# Slieveacurry Renewable Energy Development

Stage 1 Road Safety Audit

Alan Lipscombe Traffic & Transport Consultants

April 2026

### Location 5 - L1076 / L6230 junction

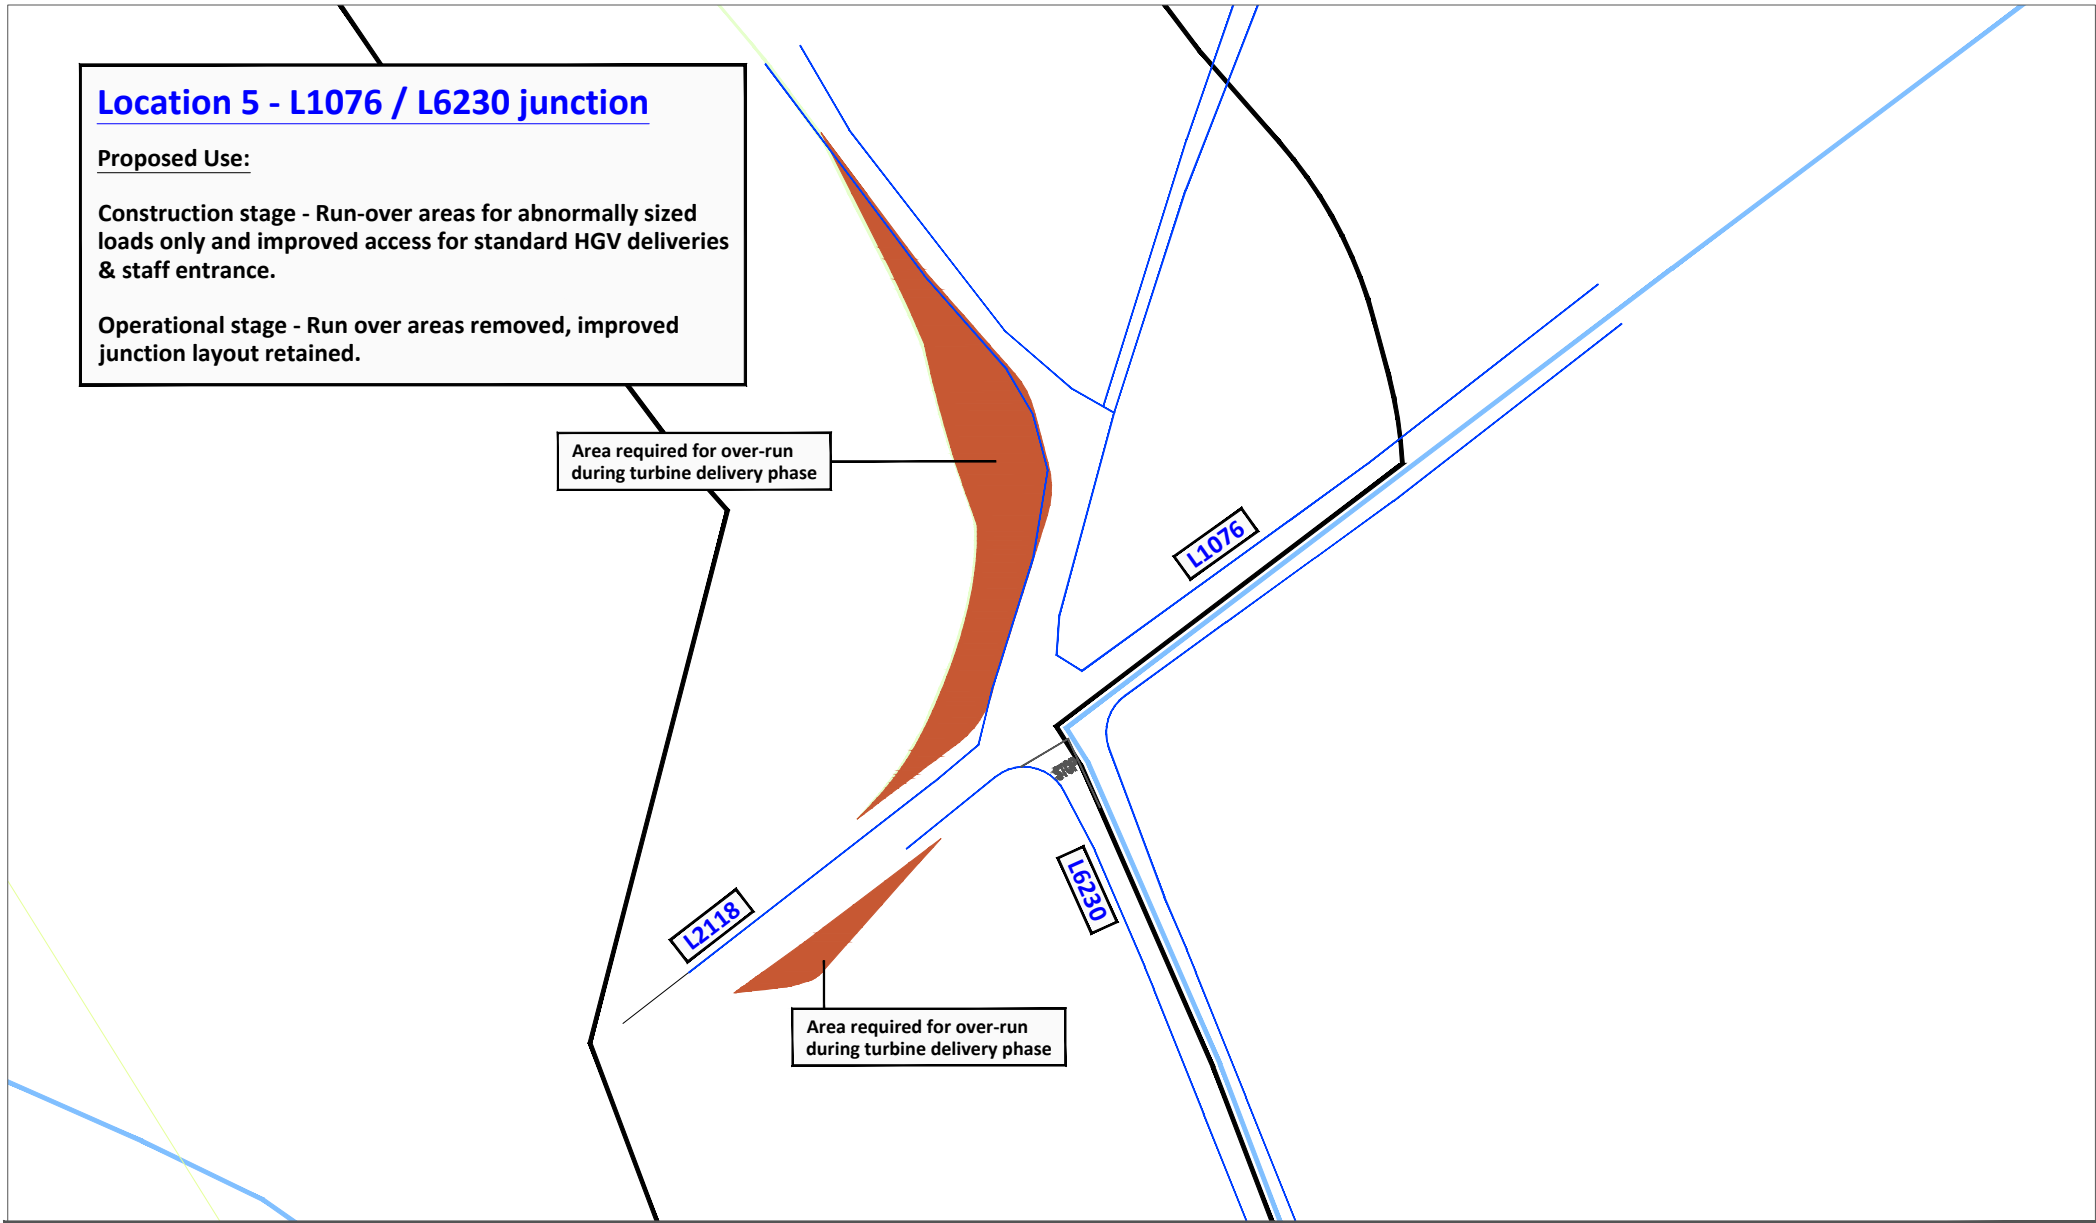
Drivers attempting to turn left or right at the junction will have their view blocked in both directions by the existing field boundaries. This limited visibility could increase the risk of side-impact collisions at the junction.

The field boundaries should be modified to ensure that an appropriate level of visibility can be provided for drivers exiting the access.

The temporary over-run area might create confusion for passing motorists, who could access it by mistake, leading to sudden braking, loss of control or conflicts with construction traffic.

The Designer should ensure that a suitable barrier is put in place to prevent passing motorists from accessing the abnormal load overrun area when it is not in use.

2.1	Location 1   For Record Purposes Only. No Safety Issues Identified.			
2.2	Yes	Yes	The required visibility splays are shown in Figure 15-15. It is noted that the visibility splays at this existing junction are partially constrained by shrubs and bushes on the southern verge of the L1076 between the carriageway edge and the boundary fence to the east and west of the junction with the L6230. As this is an existing junction it is assumed that maintenance works will be undertaken by Clare County Council to provide the required visibility splays at this junction. In the event that the splays are not maintained by Clare County Council, temporary traffic management measures, including traffic signs and the presence of a Flagman, will be introduced at this location on busy delivery days associated with the Proposed Project.	Noted and accepted

2.3	Yes	Yes	A suitable barrier will be installed at all times and opened only on the nights that the abnormal loads are delivered	Noted and accepted
2.4	Yes	Yes	It is confirmed that the visibility splays and forward visibility shown in Figures 15-19a / 15-19b will be provided at all times.	Noted and accepted
